City of Portland, Maine - Building or Use Permit Application
 389 Congress Street, 04101 Tel: (207) 874-8703, Fax: (207) 874-8716

Permit No: 09-0026	Issue Date:	CBL: 306 B006307
------------------------------	--------------------	----------------------------

Location of Construction: 59 Rain Maker Dr Unit#7	Owner Name: Ellen LLC	Owner Address: 100 Commercial St Suite 311	Phone: 207-775-2683
Business Name:	Contractor Name: Monaghan Woodworks, Inc.	Contractor Address: 100 Commercial St Suite 311 Portland	Phone: 2077752683
Lessee/Buyer's Name	Phone:	Permit Type: Change of Use - Commercial	Zone:

Past Use: Commercial /Vacant Space - Building #3, unit#7	Proposed Use: Commercial Storage Building 3, unit#7 - Establish use of space for commercial storage - Hammers, saws, staging etc. Contractor Storage	Permit Fee: \$145.00	Cost of Work: \$4,500.00	CEO District: 5
		FIRE DEPT: <input type="checkbox"/> Approved <input type="checkbox"/> Denied Signature:		INSPECTION: Use Group: Type Signature:
Proposed Project Description: Commercial Storage unit#7 - Establish use of space for commercial storage - Hammers, saws, staging etc.		PEDESTRIAN ACTIVITIES DISTRICT (P.A.D.) Action <input type="check

2ND FLOOR FRAMING

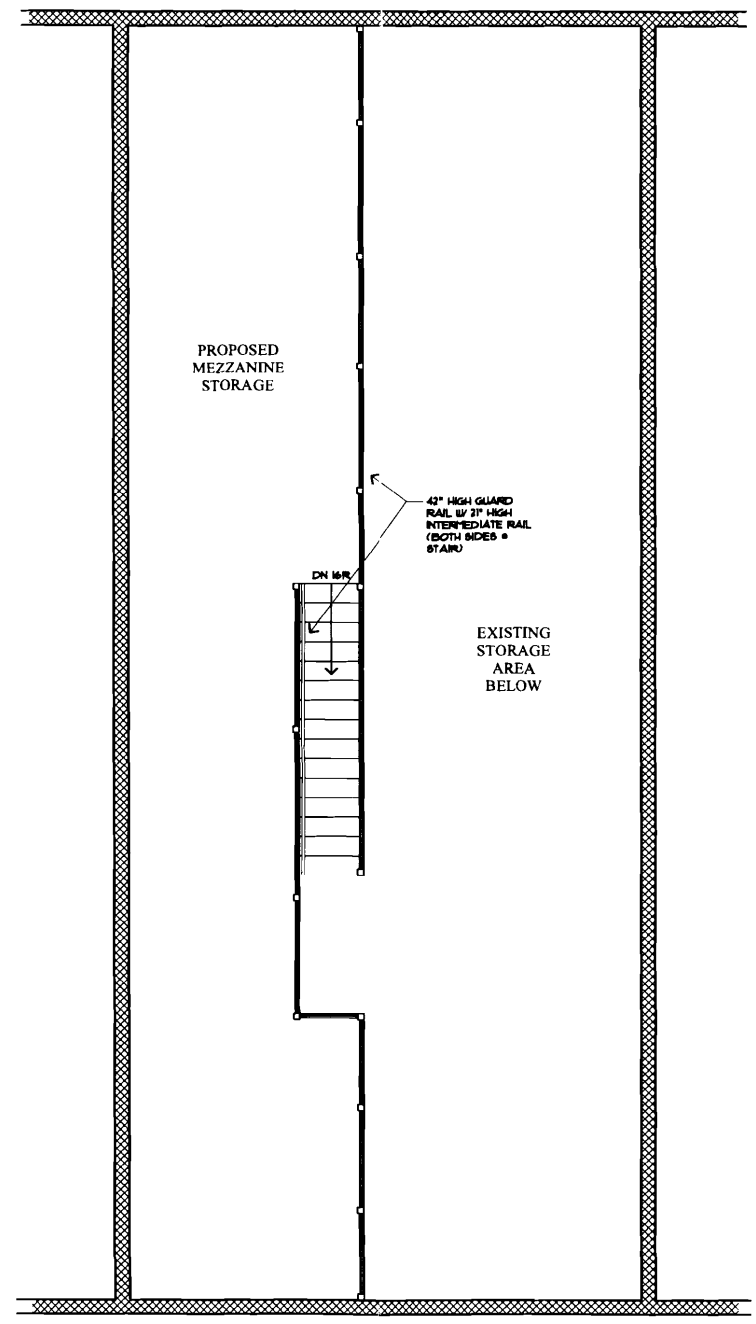
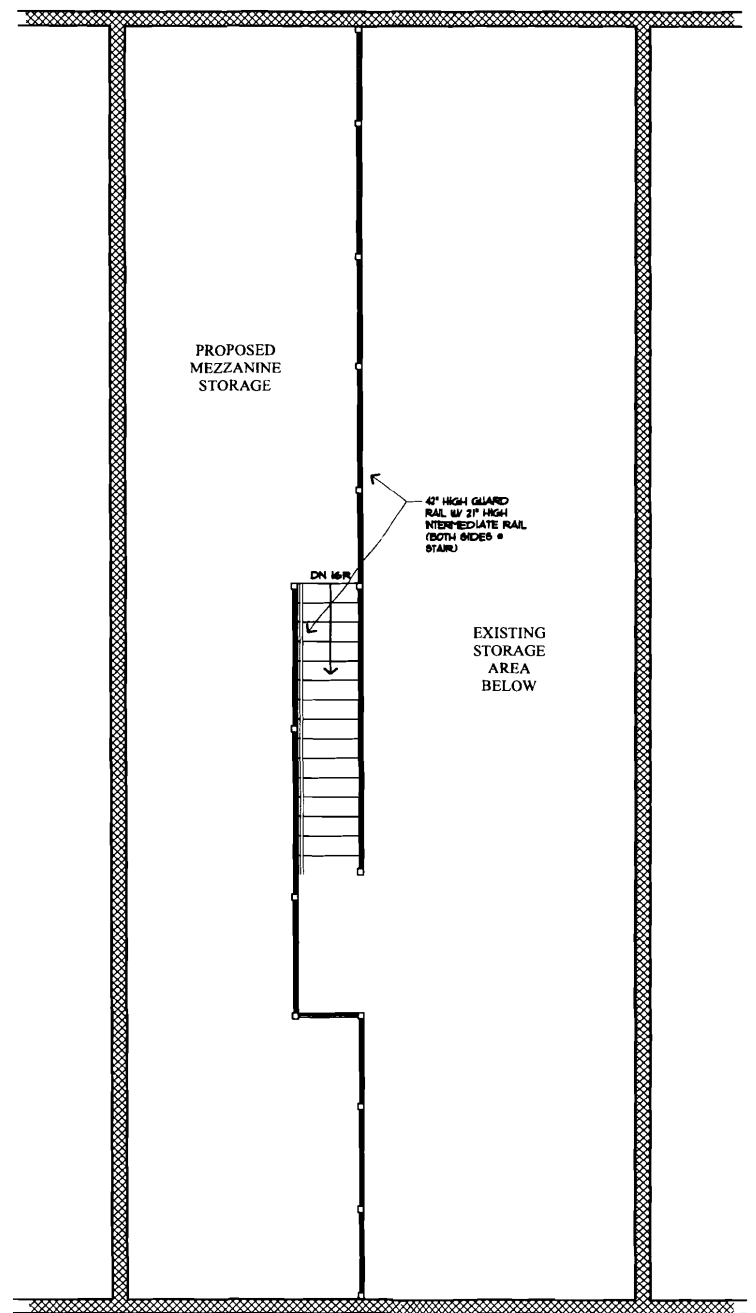
- 1) This added floor does not meet the criteria for a mezzanine, it is considered a story. It does comply with requirements for egress and storage occupancy.
- 2) Slab thickness to be verified on site by inspector and if less than 6" a detail shall be submitted to show adequate structural support or load spread.
- 3) Fasteners and connectors to be installed per IBC 2003 Sec. 2304.9
- 4) Separate permits are required for any electrical, plumbing, HVAC or exhaust systems. Separate plans may need to be submitted for approval as a part of this process.
- 5) Application approval based upon information provided by applicant. Any deviation from approved plans requires separate review and approval prior to work.

1/20/2009-jmb: Left voicemail for Mike R. For details on bearing points at posts, handrail detail and stair profile.
